From: ENVU Biodiversity and Land Use
Sent: 04 March 2025 12:14
To: Planning ContactCentre
Cc: Louise Bearcroft
Subject: RE: Attached letter from Kirklees Council regarding application number 2024/92553 at location Wappy Springs Inn, Lindley Moor Road, Lindley Moor, Huddersfield, HD3 3TD

Please see ecological / biodiversity response:

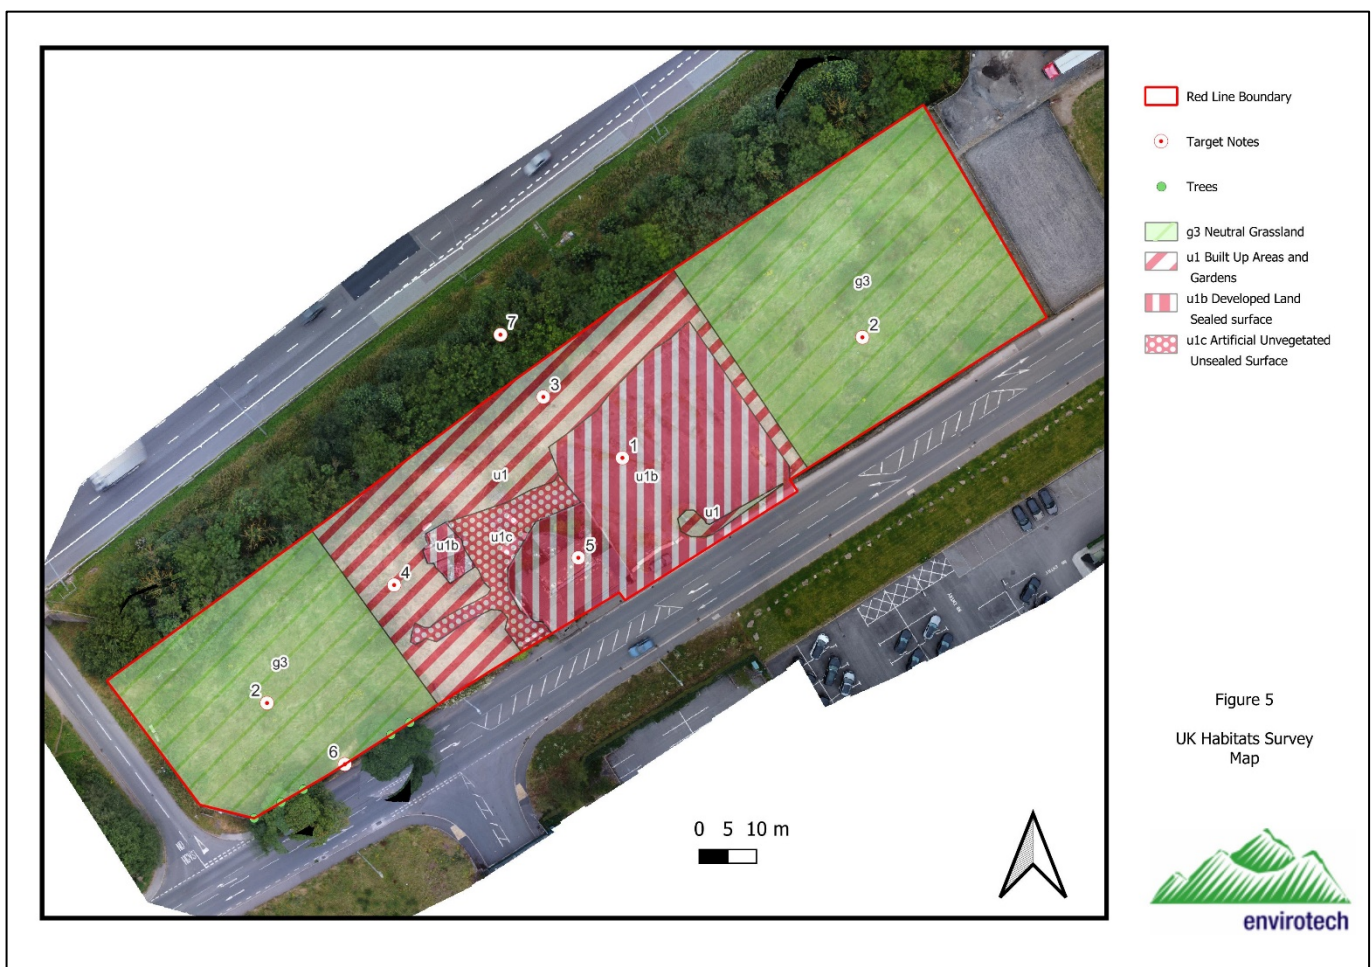
Though a minor BNG is to be achieved on-site (<0.5), the trading rules are not satisfied due to the loss of 0.18 units of neutral grassland of moderate distinctiveness. Though the recommendation has been suggested to achieve this trading rule with a local habitat bank or statutory credits, it would be important for the council that all trading rules are achieved with on-site BNG. As a result, the gain plan for this application must present a viable proposal for achieving net gain. As this may involve more on-site land than currently allocated within the red line, it is recommended that the proposal is reconsidered prior to determination of the application.

A reviewed BNG Assessment and excel format of the statutory metric should be provided before the decision notice is finalised and further planning conditions are provided.
